From: Michael Way [REDACTED]
Sent: 27 November 2018 10:32
To: Andrew Wood
Subject: Re: M/101/18/PL - 134 Elmer Road - Middleton on Sea

M/101/18/PL - 134 Elmer Road - Middleton on Sea

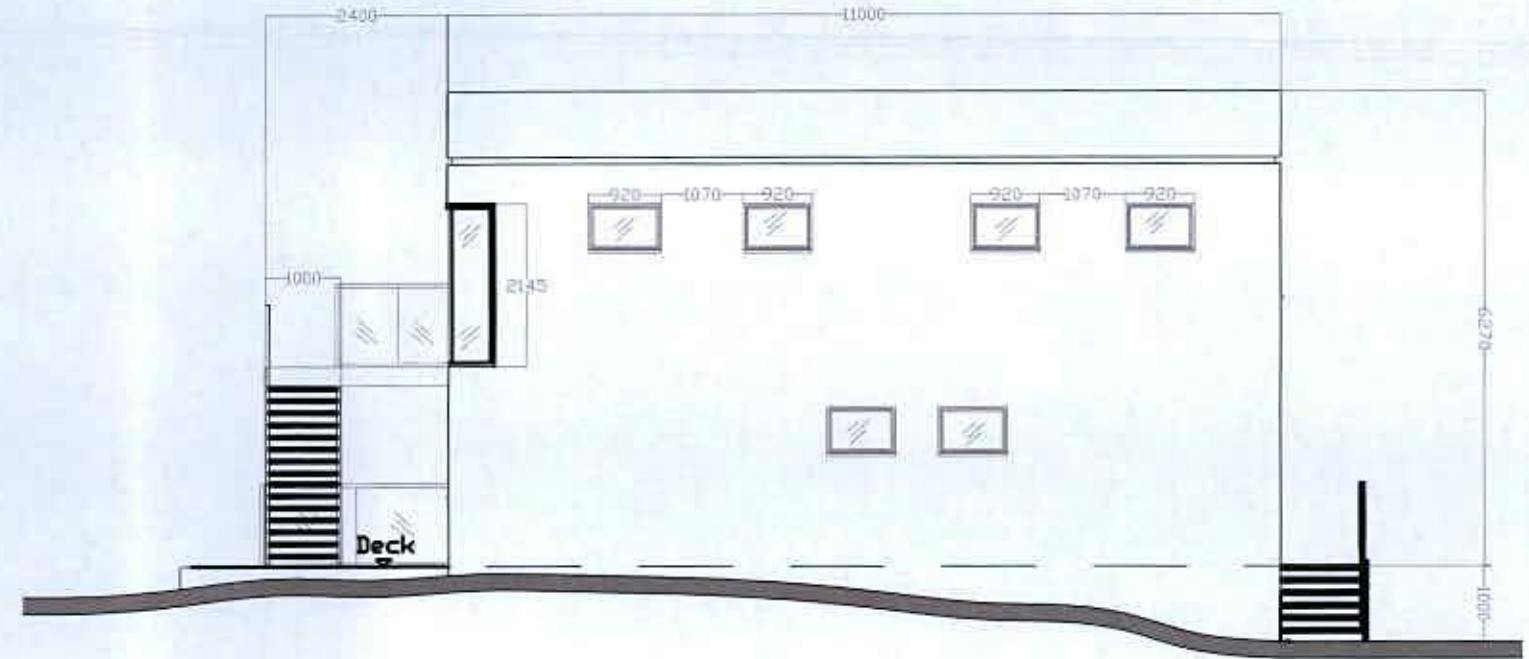
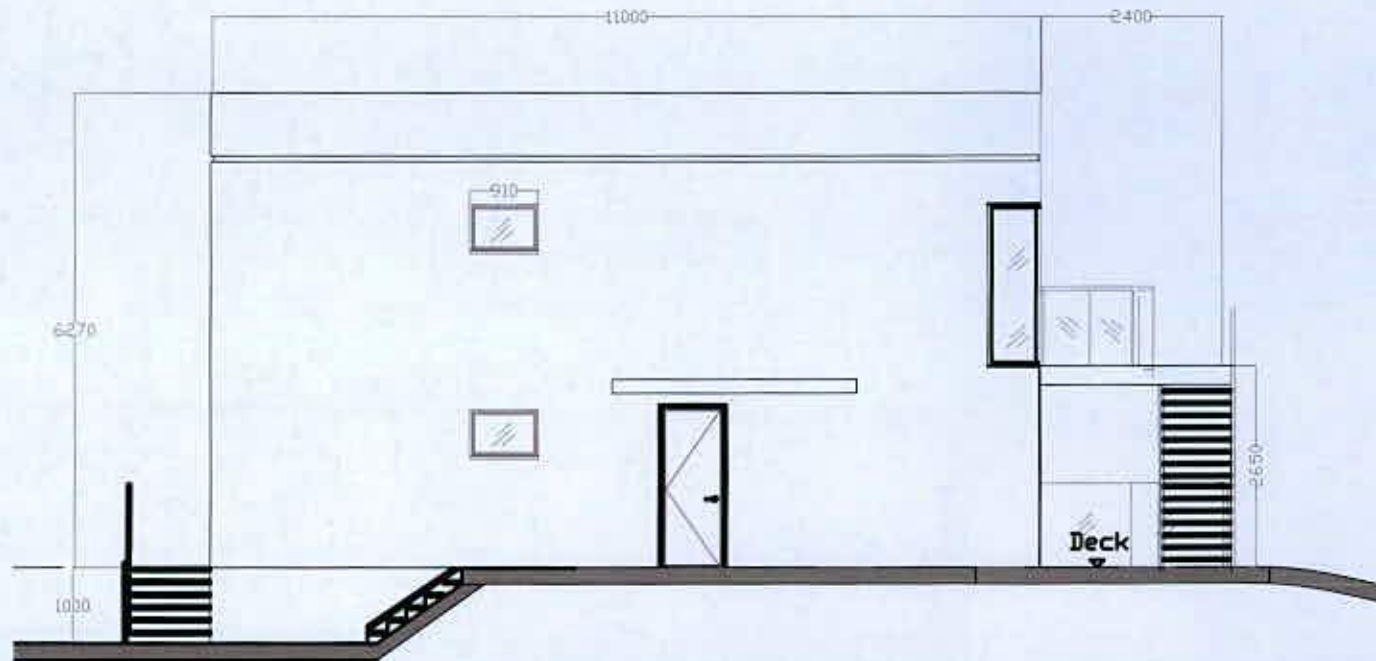
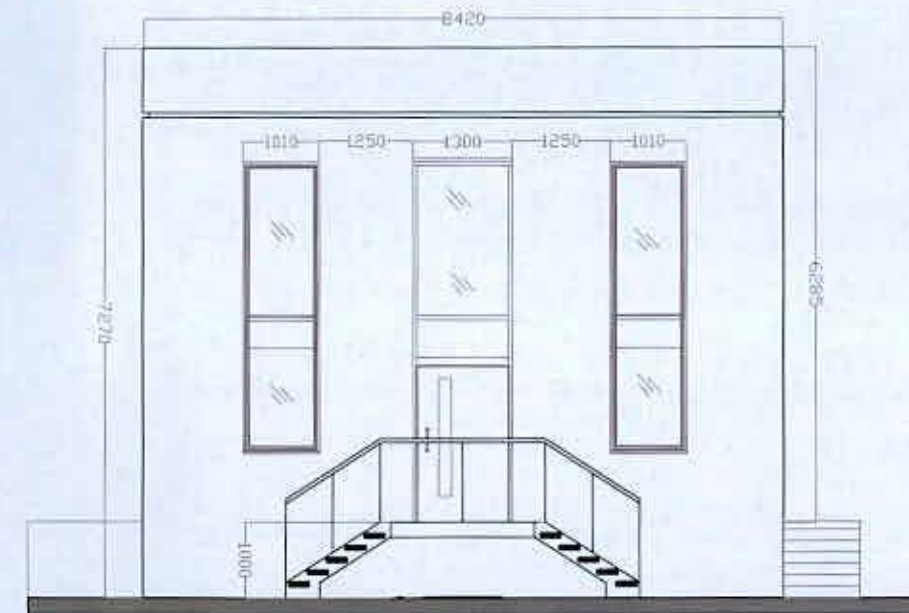
- 1) Whether or not you are applying for a residential use or a commercial holiday home use.
- 2) Opaque side screens to the proposed balcony as requested in the pre-application advice.

This email has just landed, but I think we have already discussed the two issues you refer to.
